# CITY OF ALBUQUERQUE

December 1, 2021

**Re: EL Encuentro Immigrant Community Center**  
**907 4<sup>th</sup> Street SW**  
**Traffic Circulation Layout (TCL)**  
Architect's Stamp 10-15-2021 (K14-D121)

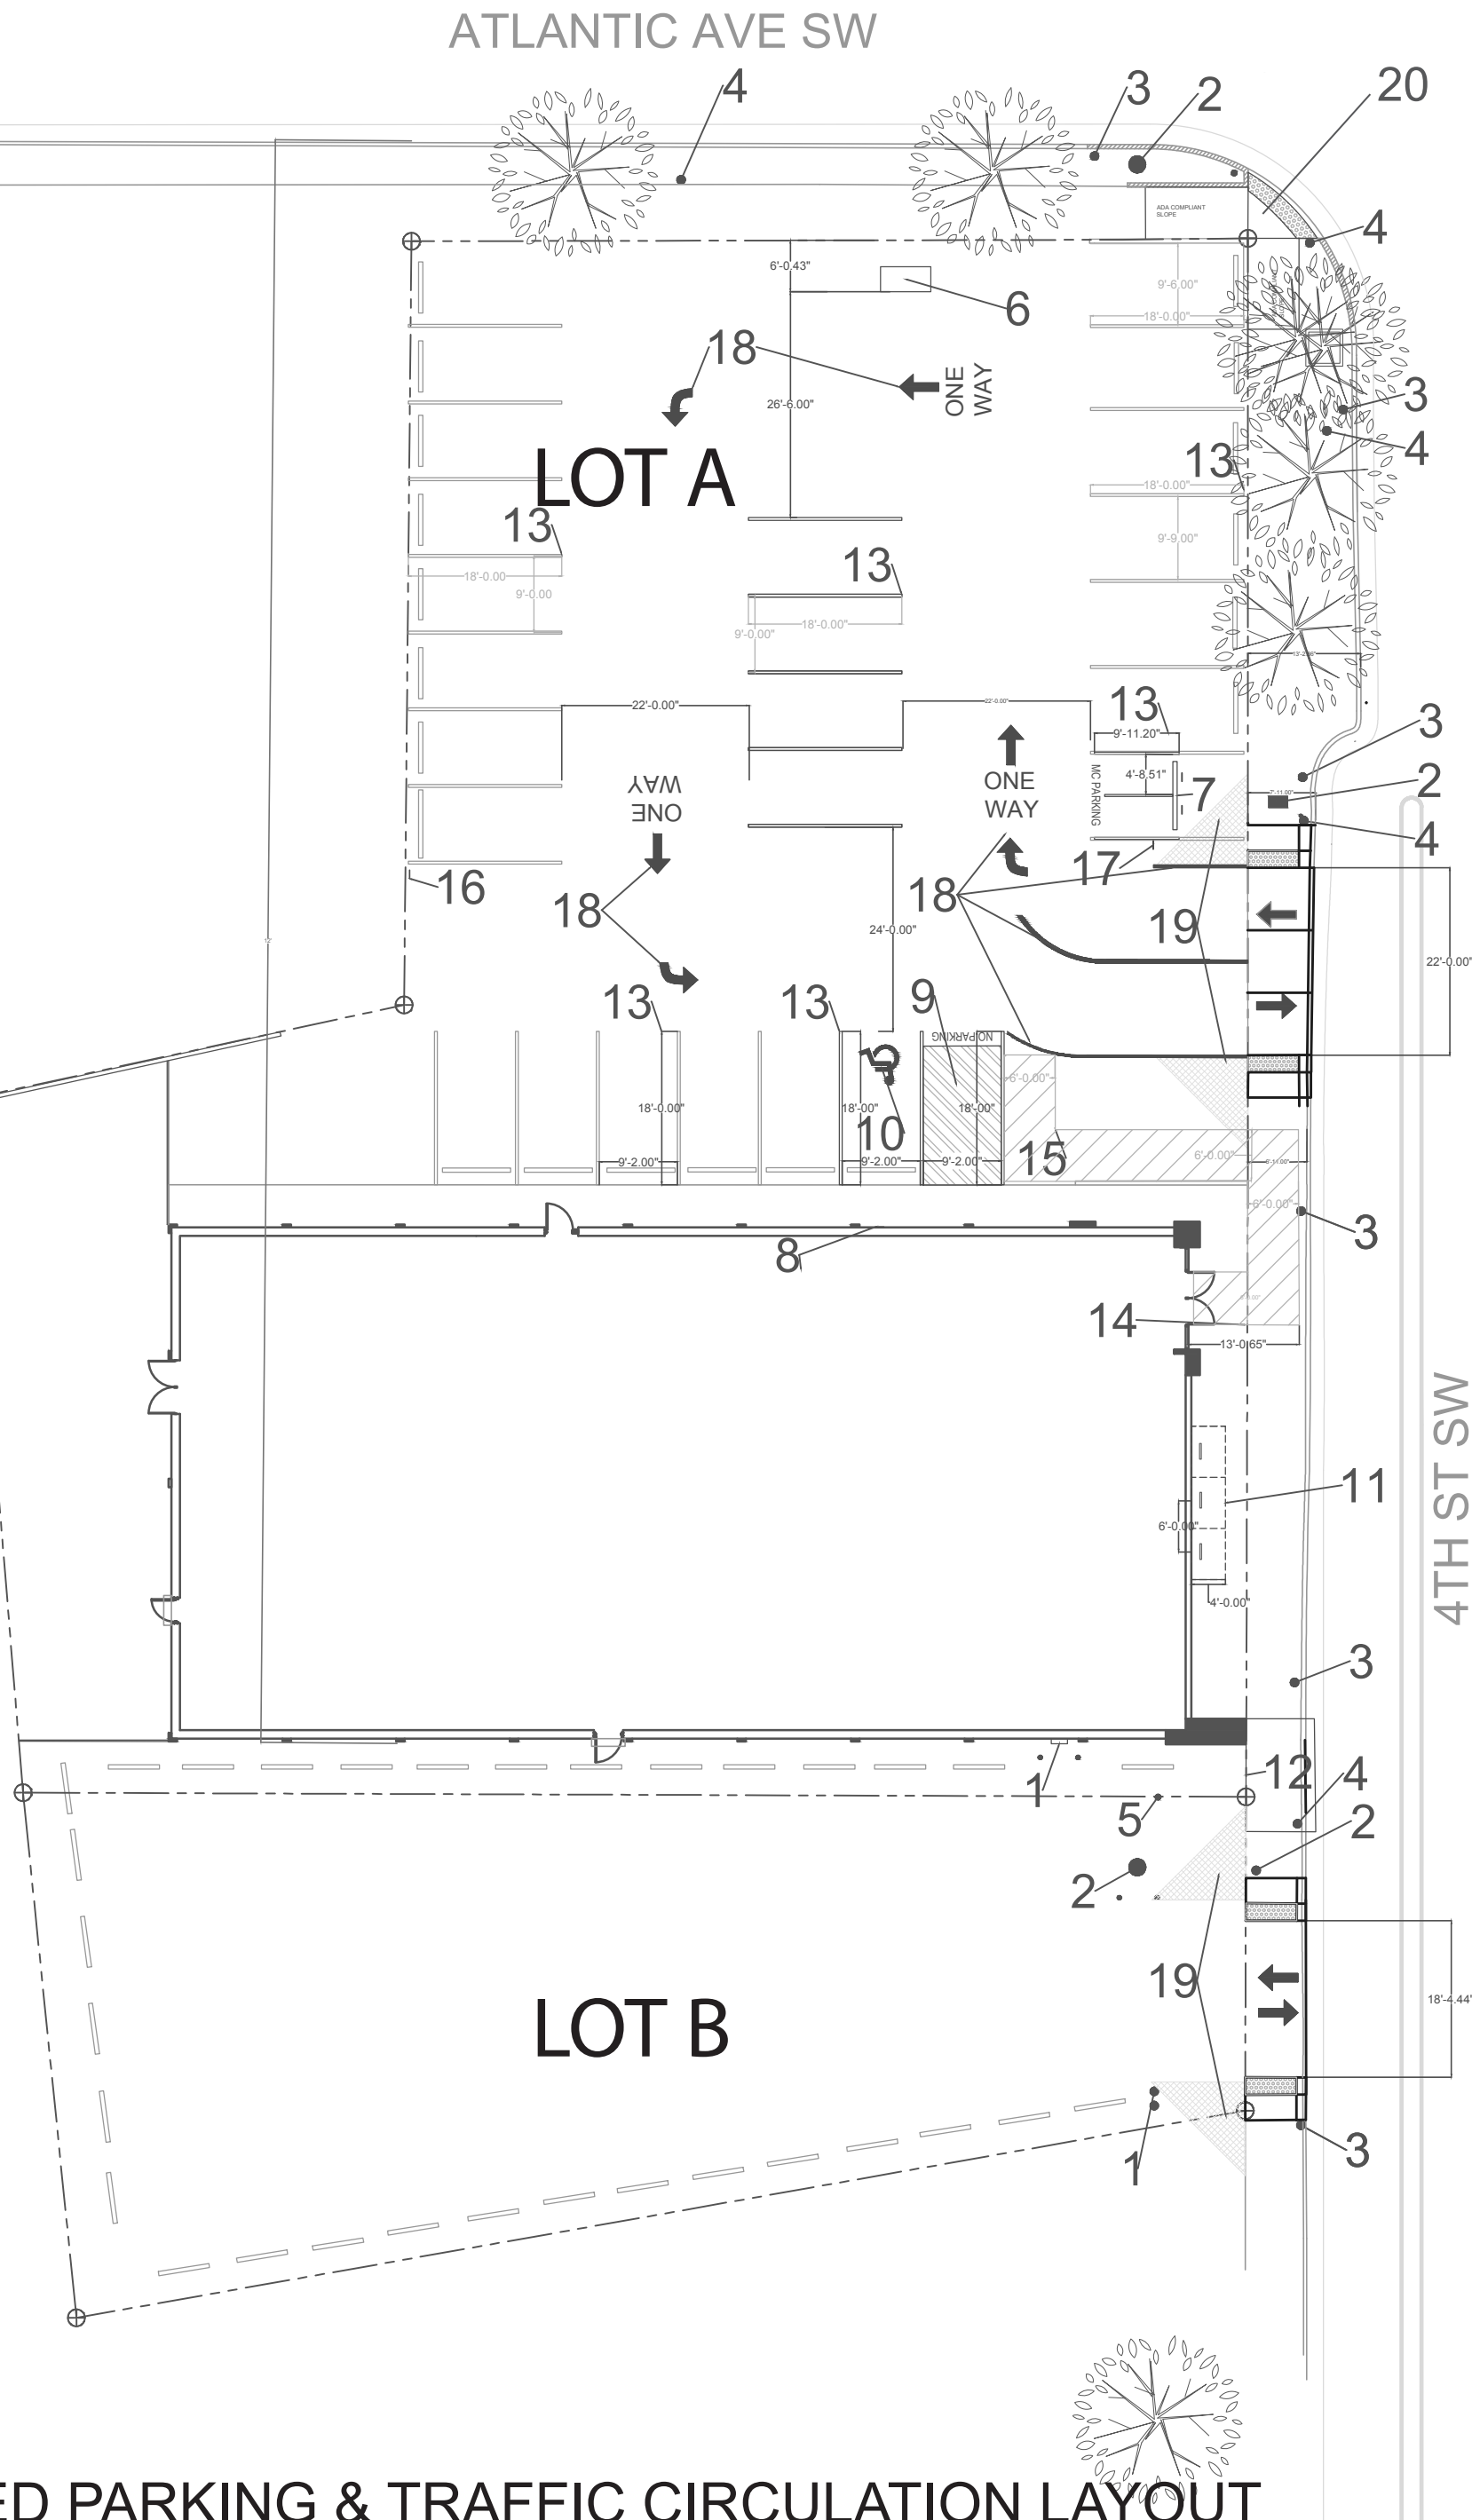
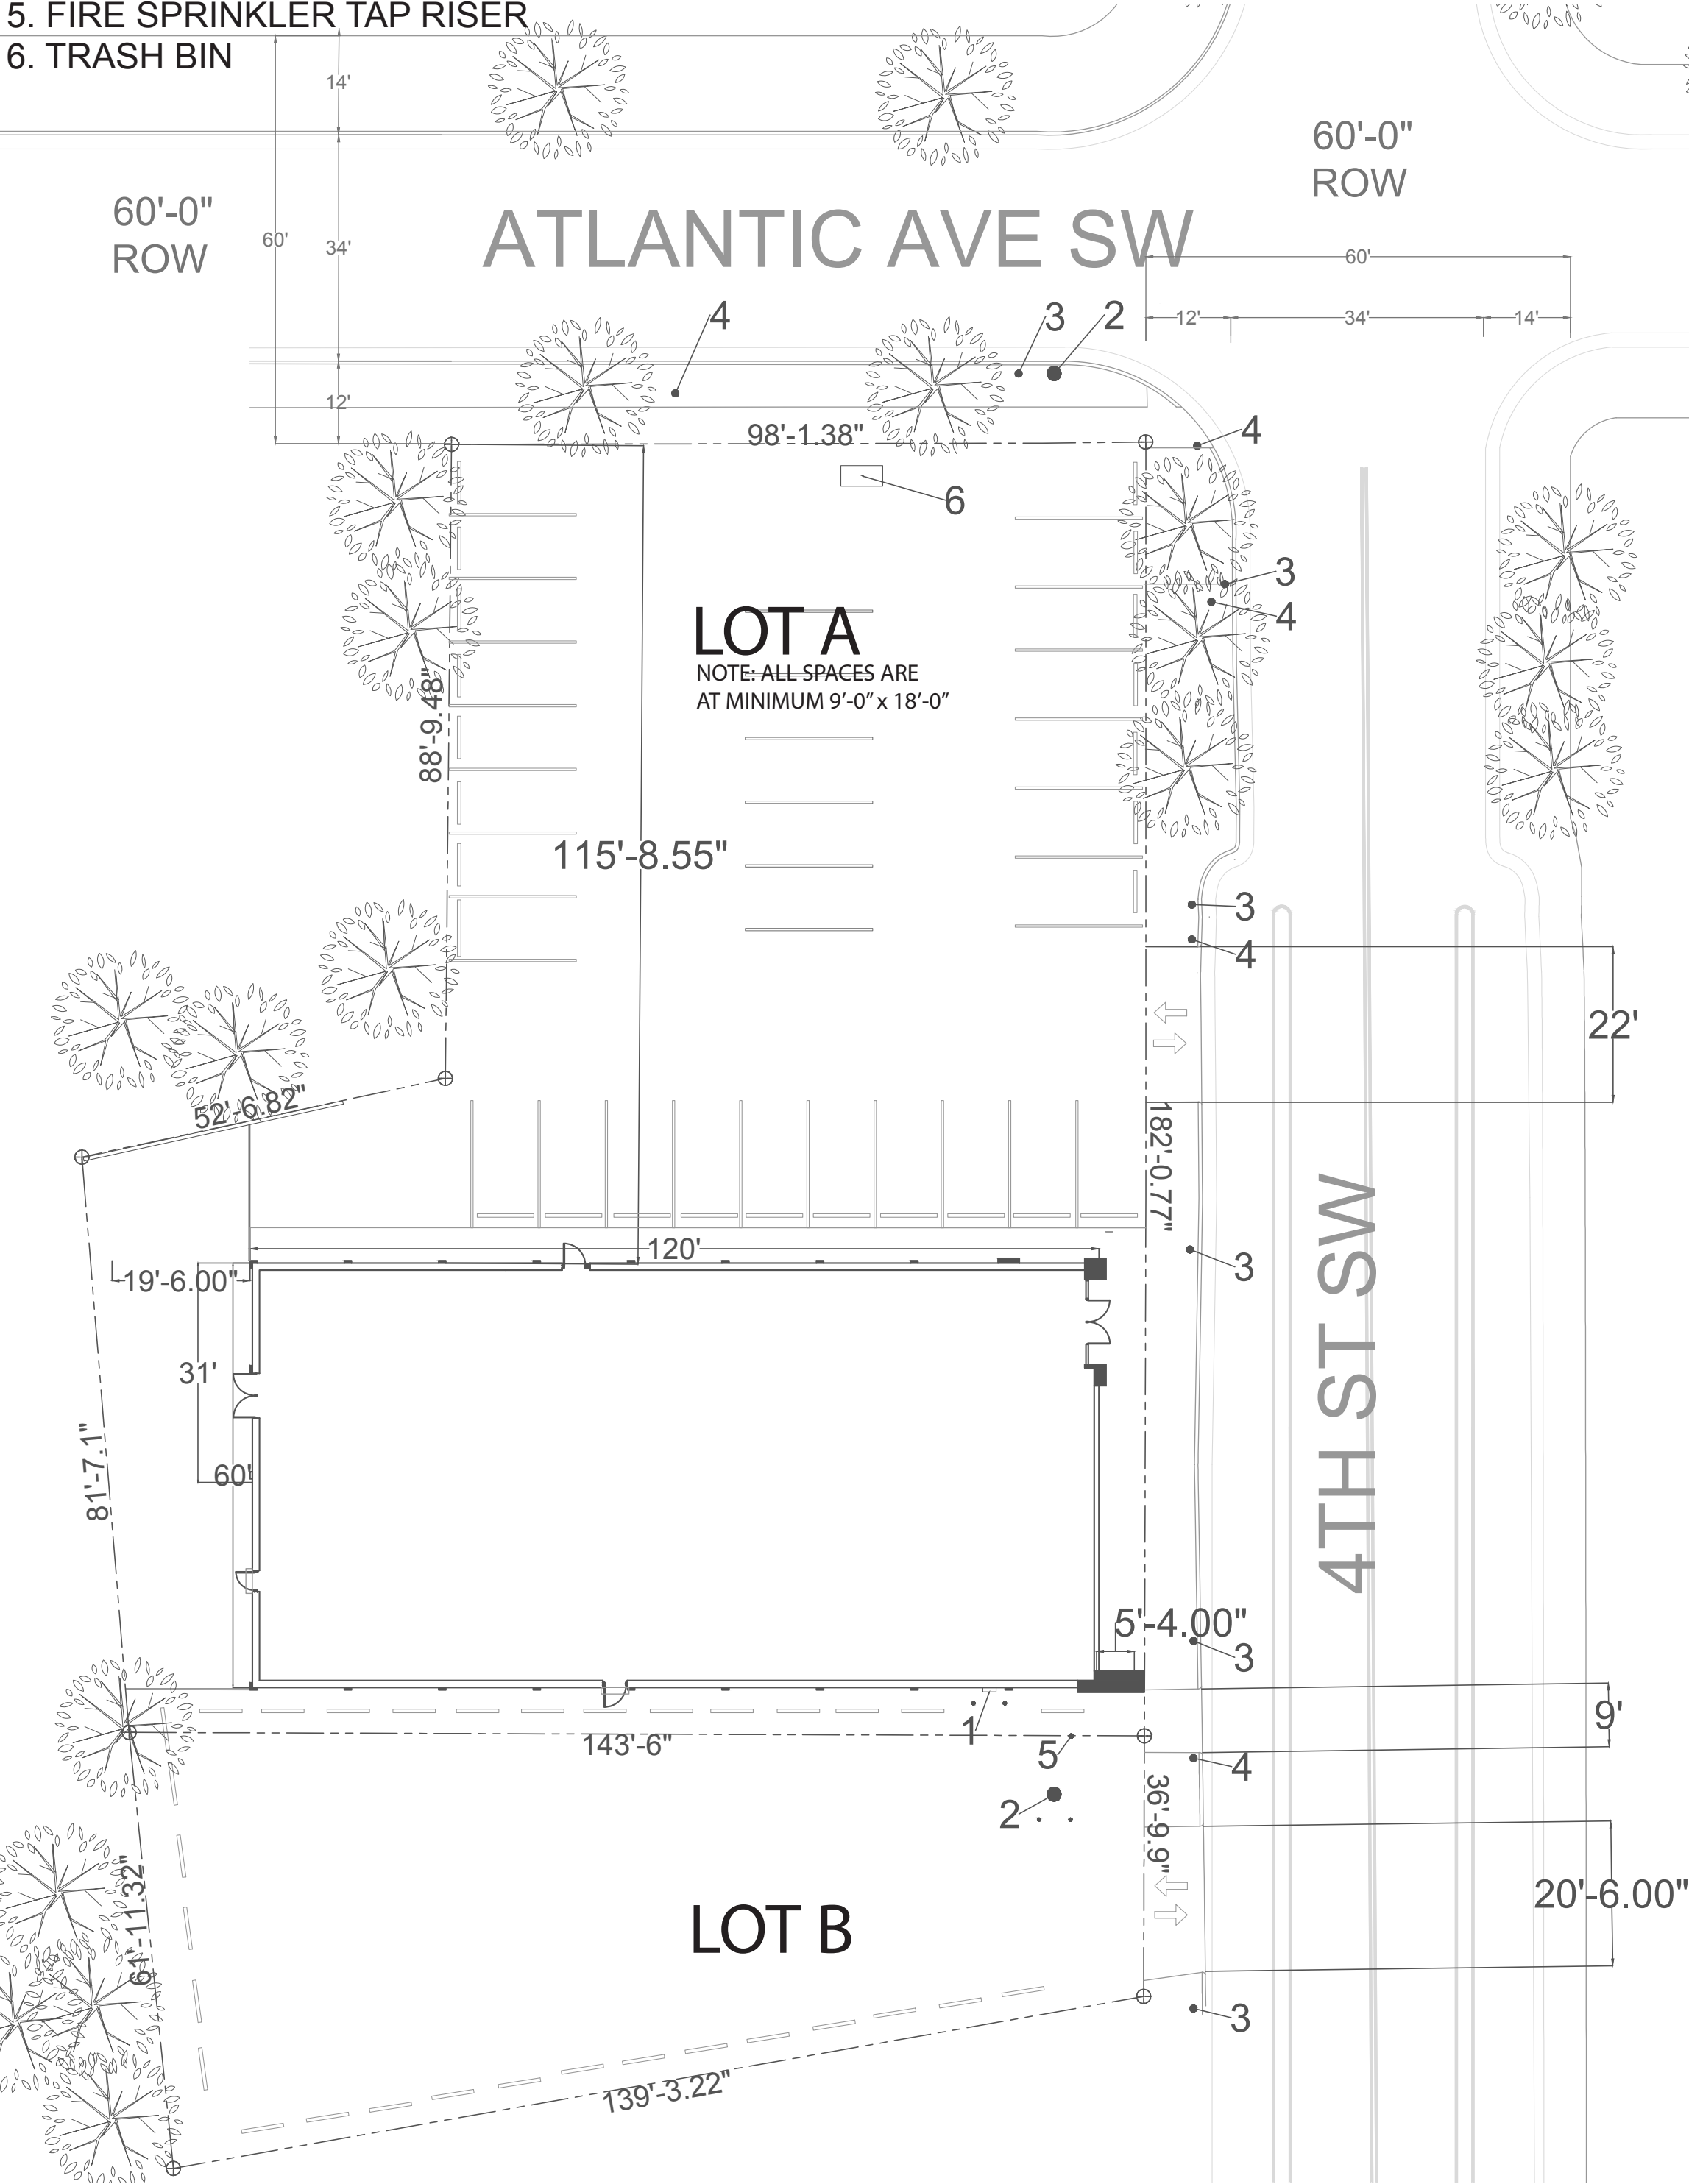
5. **Lot ( 909 4<sup>th</sup> SW):**
  - The lot belongs to to the Community Center and needs to be shown on site plan **(Being used for over flow parking).**

- There are two drivepads. One drivepad is shared with the northern property and will need to be close as it serves no function at present moment. See comment 26 notes to provide closure notes.

10. The ADA accessible spaces must include an access aisle. Van accessible aisles should be 8ft wide; all others should be 5ft wide.
11. The ADA accessible parking sign must have the required language per 66-7-352.4C NMSA 1978 **"Violators Are Subject to a Fine and/or Towing."** Please call out detail and location of signs.

12. The ADA access aisles shall have the words **"NO PARKING"** in capital letters, each of which shall be at least one foot high and at least two inches wide, placed at the rear of the parking space so as to be close to where an adjacent vehicle's rear tire would be placed. (66-1-4.1.B NMSA 1978). Provide detail for access aisle striping, symbol, and sign face detail.

13. ADA curb ramps must be updated to current standards and have truncated domes installed (**Corner of Atlantic/4<sup>th</sup>**). Verify.
14. Motorcycle parking spaces shall be designated by its own conspicuously posted upright sign, either free-standing or wall mounted per the zoning code. Label pavement MC. Provide details for sign face and pavement marking.

### **Bicycle Rack requirements below (if applicable):**

19. Per the DPM, a 6 ft. wide ADA accessible pedestrian pathway is required from the public sidewalk to the building entrances. Please clearly show this pathway and provide details.

20. Per DPM, a 6 ft. wide ADA accessible pedestrian pathway is required from the ADA parking stall access aisles to the building entrances. Please clearly show this pathway and provide details.

21. Provide a copy of refuse approval.
22. Fire 1 approved plan needs to be provided.
23. All one-way drives shall have "One Way" and "Do Not Enter" signage and pavement markings. Please show detail and location of posted signs and striping.

27. Delete 1-parking stall at drive aisle (south of trash bin) to assure 22 ft of aisle is provided for circulation (If applicable).
28. **Shared Site access (between lots on 907 & 909 4<sup>th</sup> St SW):** driveways that straddle property lines, or are entirely on one property but are to be used by another property, shall have an access easement. Please include a copy of your shared access agreement with the adjacent property owner.
